City of Portland, Maine - Building or Use Permit

Location of Construction:	17 CHESTNUT ST	Owner Name:	BOODILLY LLC	Owner Address:	158 WOODVILLE RD	Phone:	
Business Name:		Contractor Name:	E. W. Littlefield, Inc. & Sons	Contractor Address:	2715 Athens Road Harton	Phone	(207) 938-2661
Lessee/Buyer's Name		Phone:		Permit Type:	Alterations - Commercial

Proposed Use:	Restaurant - Change of use from Church to restaurant interior and exterior renovations/restoration	Proposed Project Description:	Change of use from Church to restaurant interior and exterior renovations/restoration
---------------	--	-------------------------------	---

Exterior Work Yet to be Completed to Satisfy
Historic Preservation Board Approvals for 17 Chestnut Street

Mechanical Screen Fence Details
Scale: 3/4" = 1'-0"

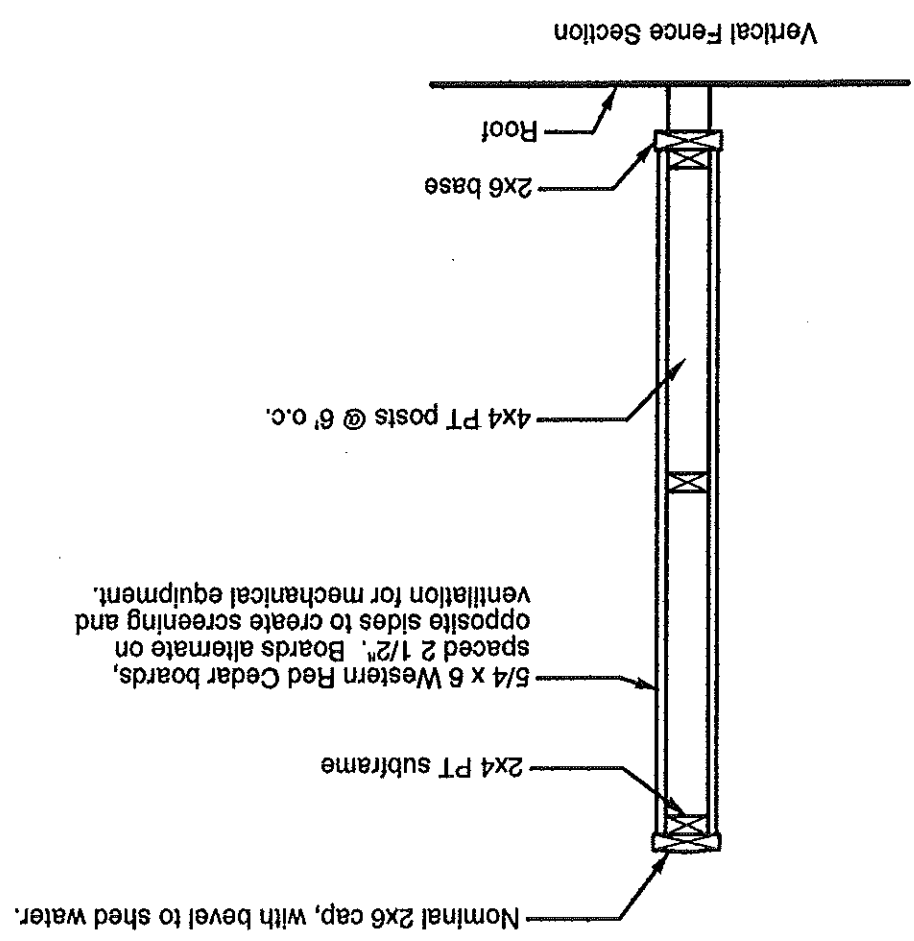
8. Final brick selection for rear corner to be approved by HP staff.
 9. Screening material for rooftop mechanicals at rear corner to be metal, rather than wood. Final details, finish and color for metal screen to be reviewed and approved by HP staff.

- * Screen to be completed as approved: 5/4" x 6" cap rail to be installed.

Elevation of Function Room Entrance/Canopy

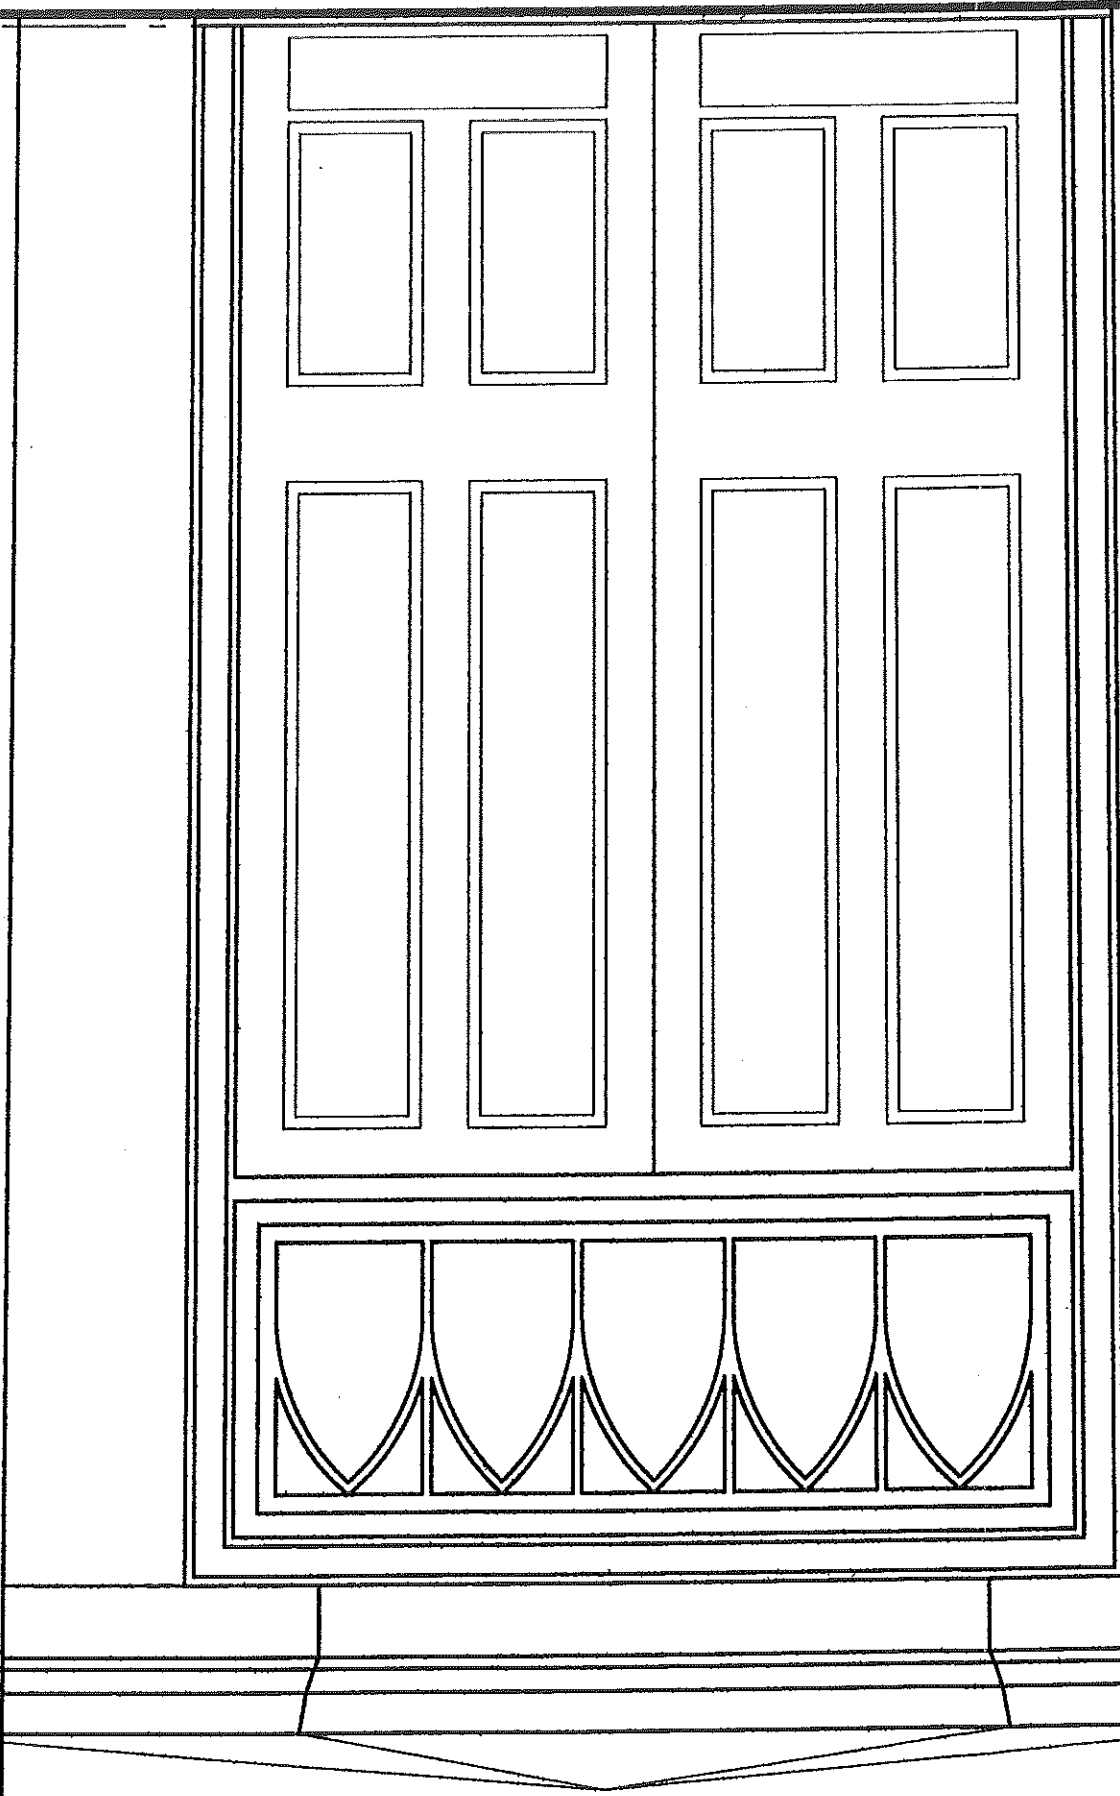
2. Location and screening of waste storage to be reviewed and approved by HP staff.
 3. Section and elevation drawings for proposed door canopies to be submitted to HP staff. Detailing of proposed canopies to be distinguished slightly from that on existin bay windows to make a distinction between original details and later additions.

Exit Stair Plans & Section

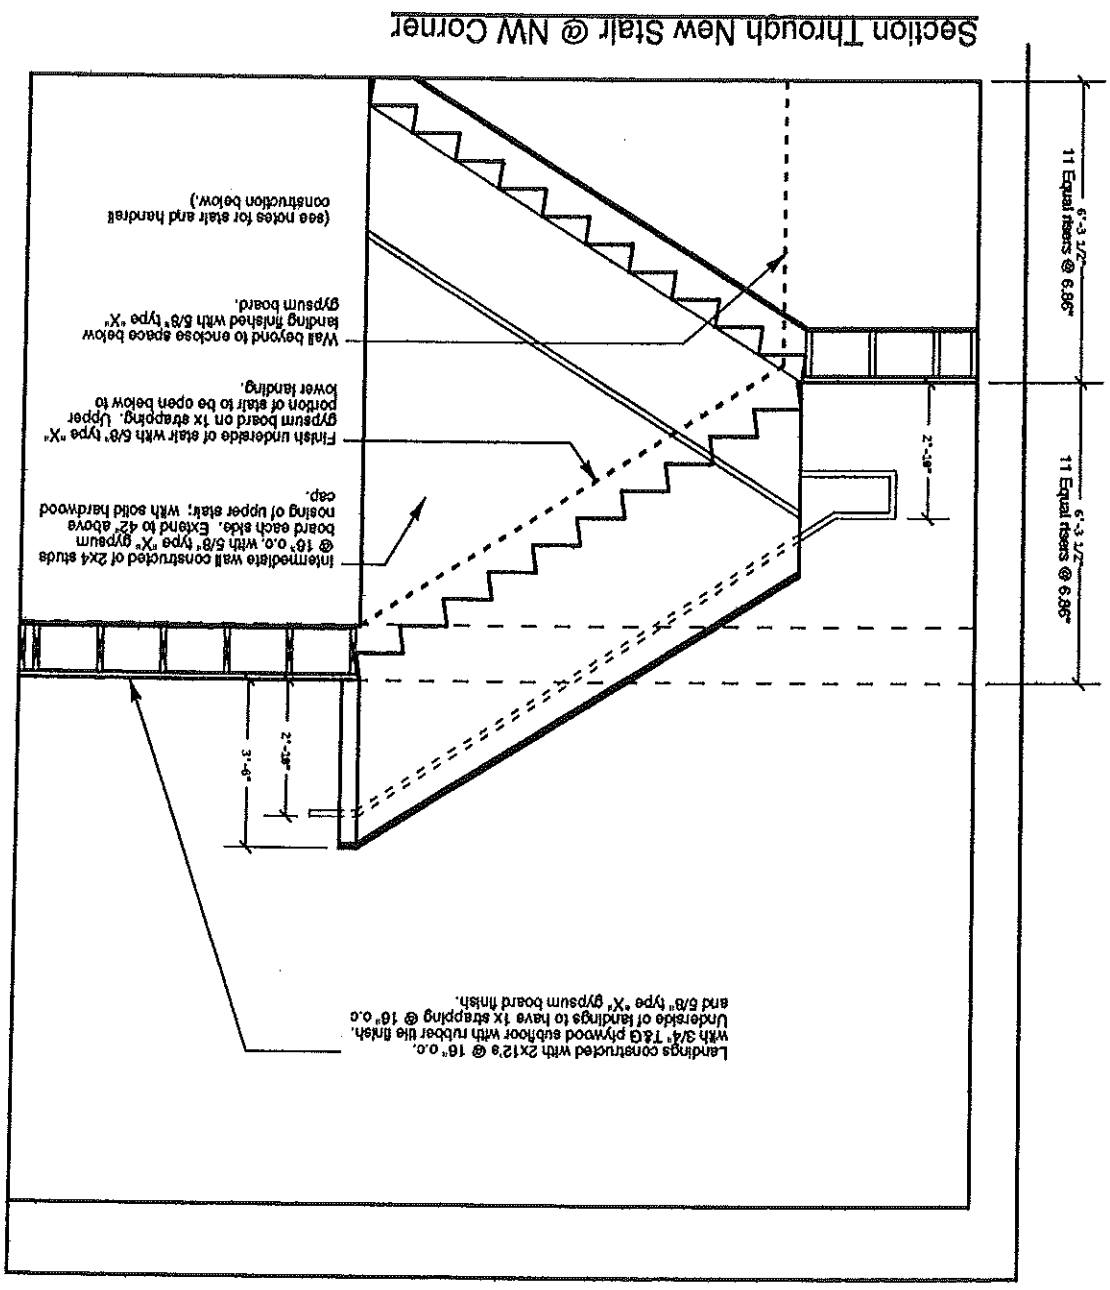
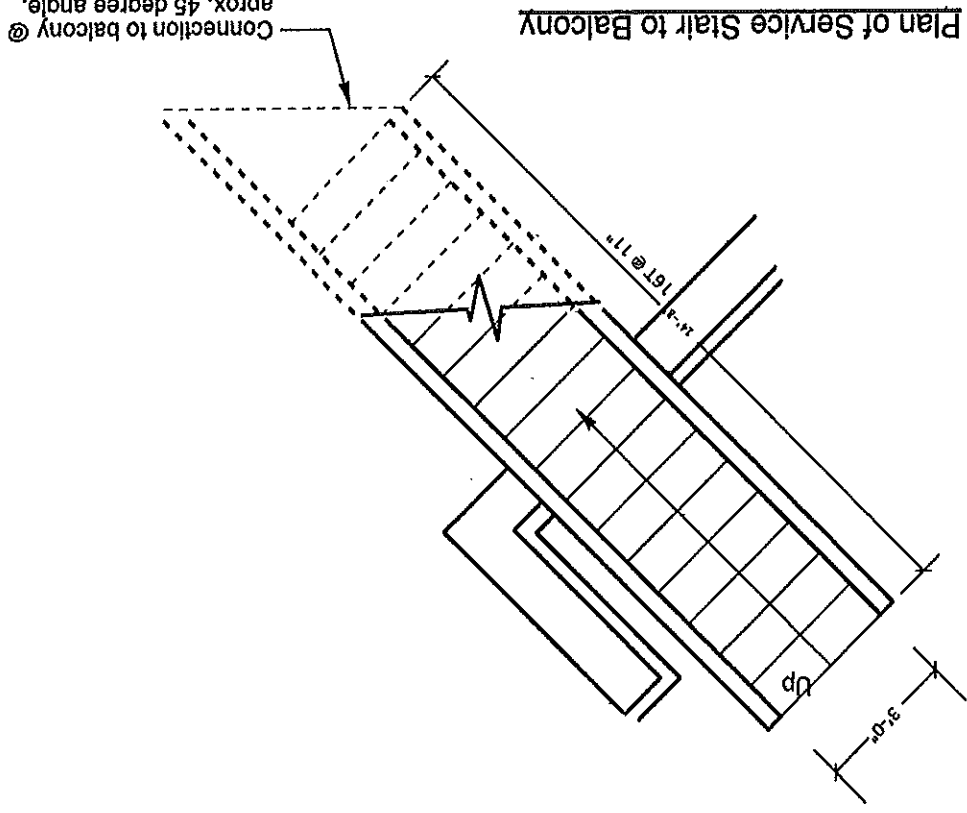
7/23/2008-jimb: Left a voicemsg with Dean B. (architect) to call. Plan review items: stair and railing details, canopy details, wall types, detail all new masonry openings or repair of existing, full kitchen, bar and service area layout with fixture locations, exterior work details, photos and typical anchoring specs, gender ID on the turret bathrooms.

7/28/2008-jimb: Spoke with Dean B. About required details, he will submit. The kitchen layout will be done by others and reviewed separately. The rear wall construction (25'-30") will need an ska detail once the area is investigated.
